**Re: Flying Horse Filing 7 Fire Protection – Response to Comments**

Below our consultant team has provided written response to comments received from Black Forest Fire Protection District on September 14, 2026. Please direct all coordination through the EDARP system to the appropriate representatives below.

**BFFD Comment 1**

FLYING HORSE NORTH SUBDIVISION FILINGS 1, 3-9
SUBDIVISION FIRE PROTECTION MAP

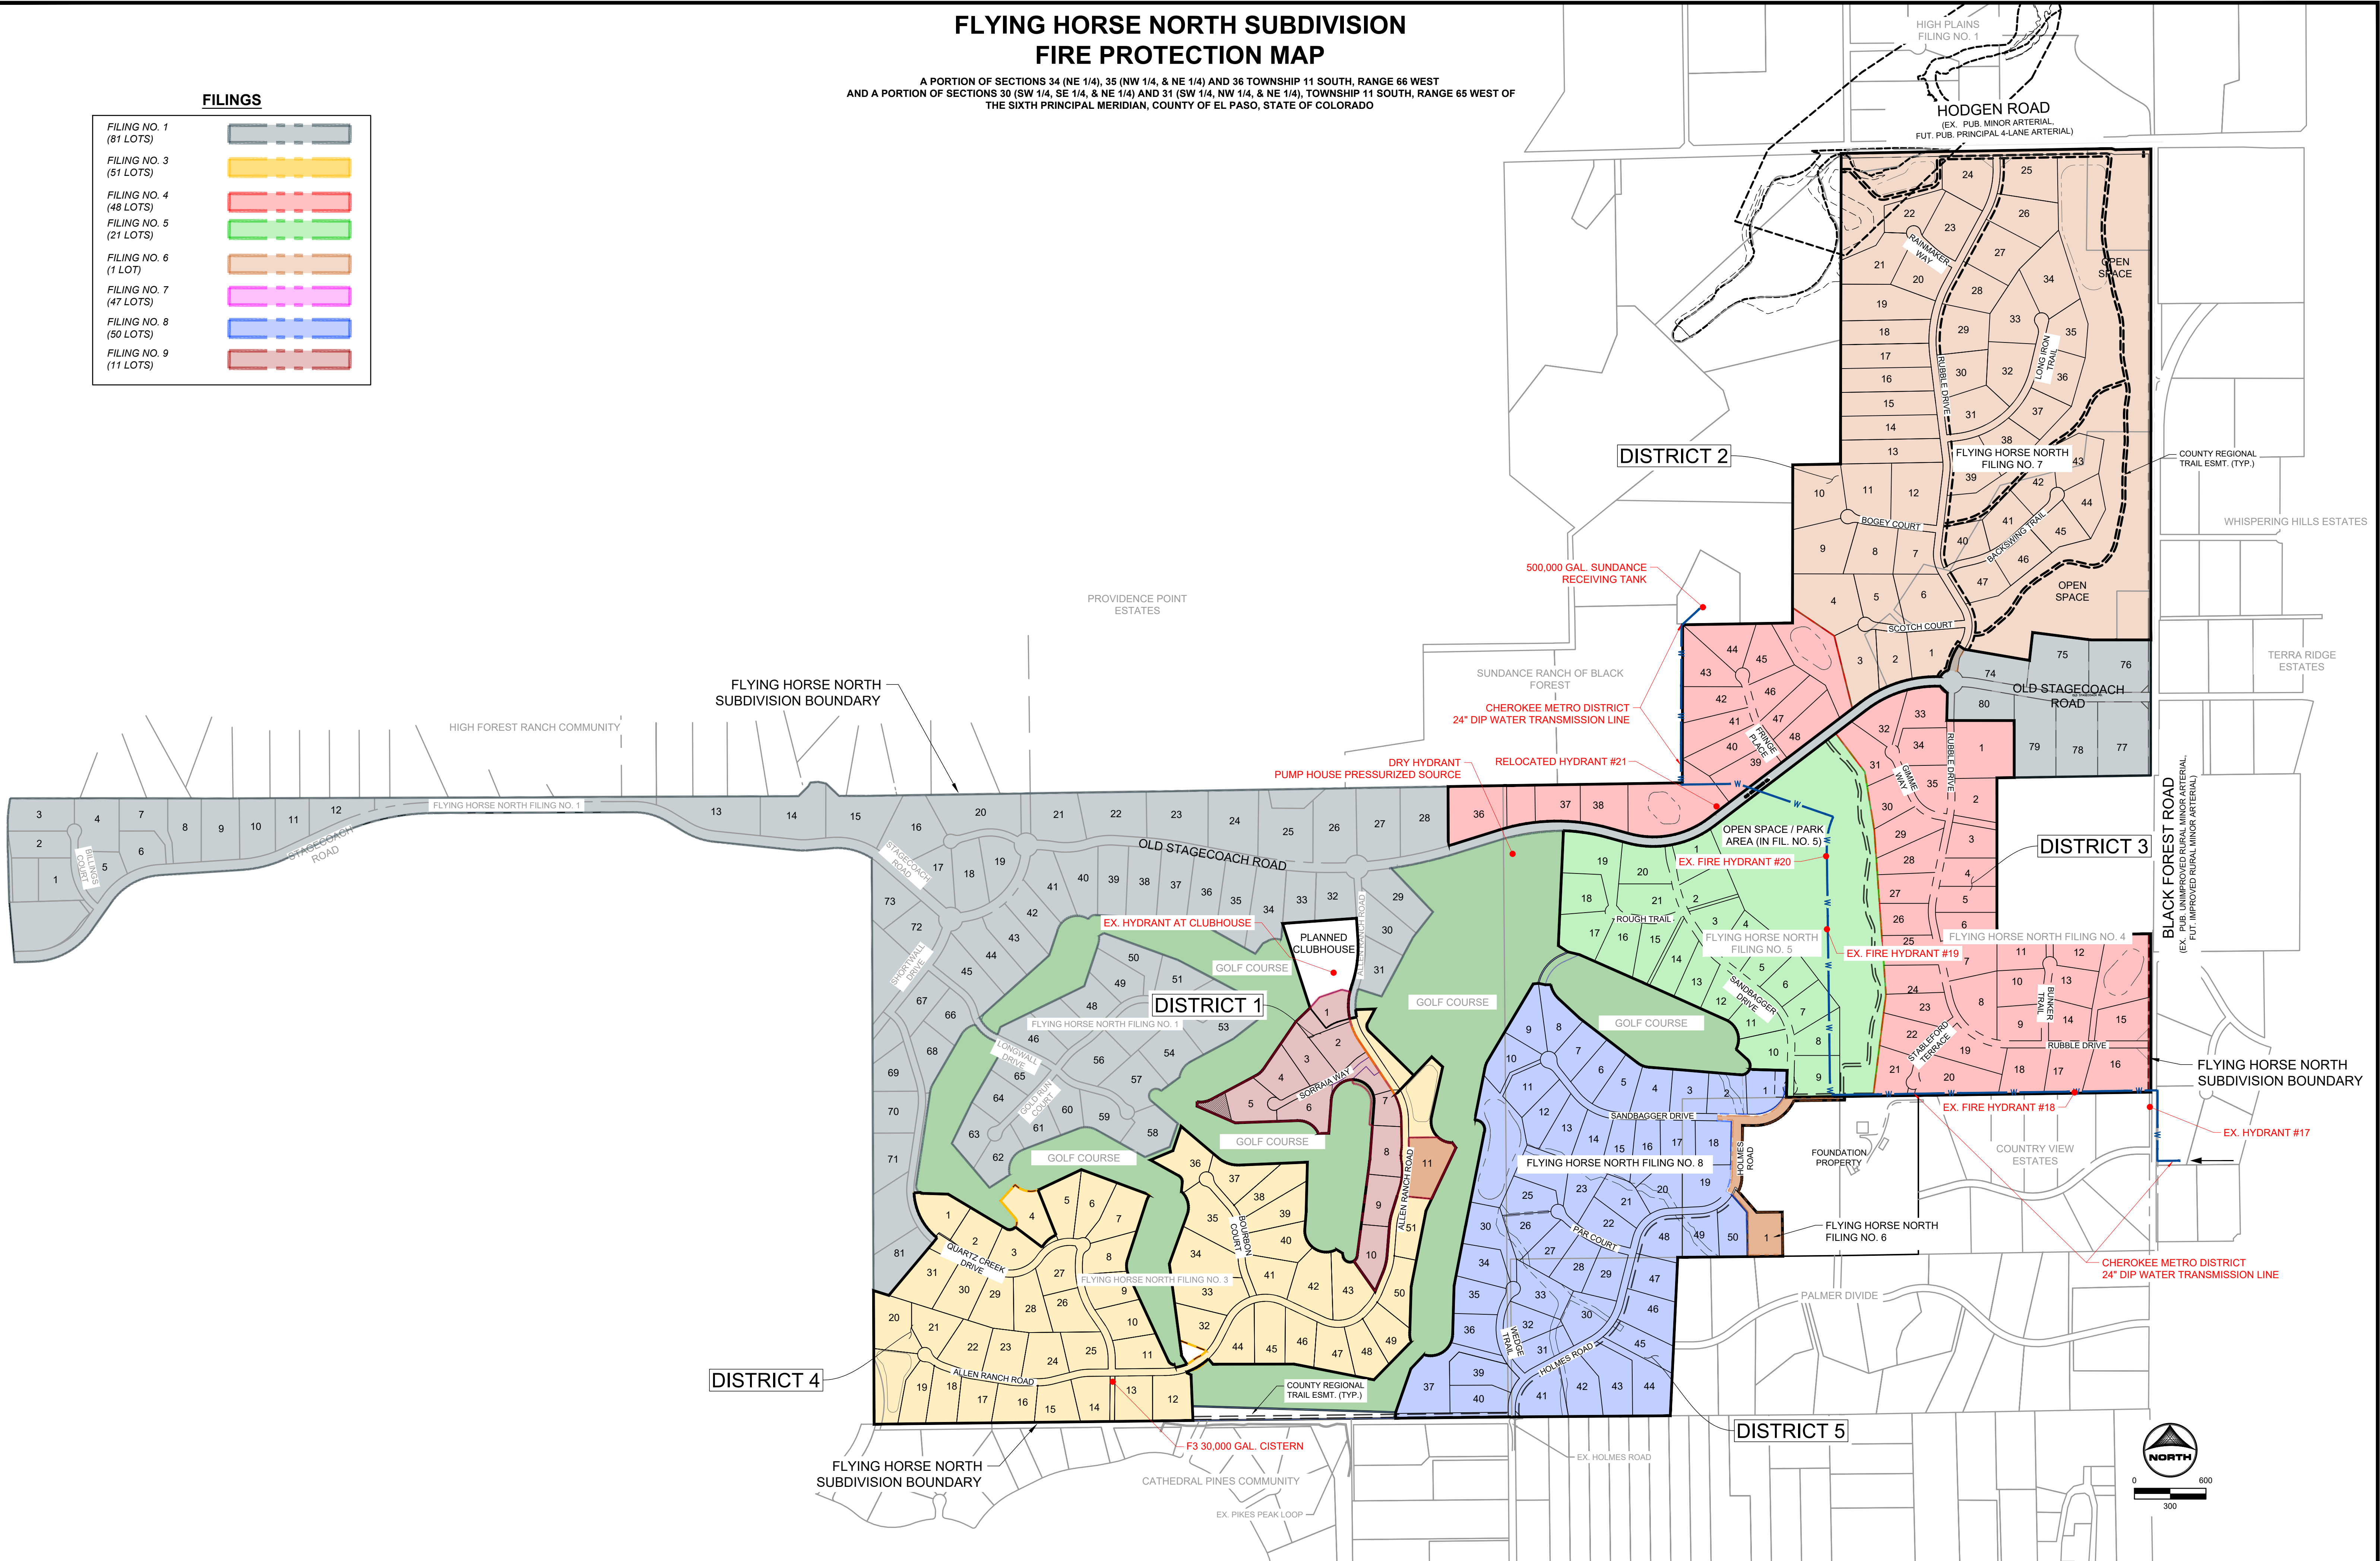
The final fire-protection water-supply method remains under discussion and has not received final approval from BFFR. The proposal to use the pressurized Sundance system, including Hydrants 17 and 21 and the existing pump-house source, requires BFFR review before it may replace the proposed cisterns.

Provide flow-test documentation for Hydrants 17 and 21 demonstrating a minimum uninterrupted flow of 250 gpm for two hours. The final fire-protection plan shall show the approved travel routes and confirm that every parcel entrance is within two miles of an approved water source. Hydrant 21 and all designated water-supply locations shall have approved all-weather apparatus access and operating areas. Hydrants shall remain visible,

unobstructed, protected from vehicle damage, marked and accessible year-round. Final connections, color coding, signs, and clearances shall meet BFFR requirements. If the proposed system cannot be legally guaranteed or demonstrated to meet the required flow, duration, distance, and access requirements, additional hydrants, cisterns, or another approved water supply may be required. Plat approval does not constitute final BFFR acceptance of the water-supply arrangement.

We assume the conditions below are those required to receive BFFR approval to use Hydrants 17 and 21 as approved firefighting water sources. See attached for revised Fire Protection Report addressing Filing 7 only.

Hydrant 21 flow test results have been included within the revised Fire Protection Report that was submitted. Hydrant 17 provides Fire Protection for the proposed Foundation Property that is already approved and under construction and is not needed for this particular filing in Flying Horse North. Final installation and maintenance requirements are noted and will become part of the HOA agreement.
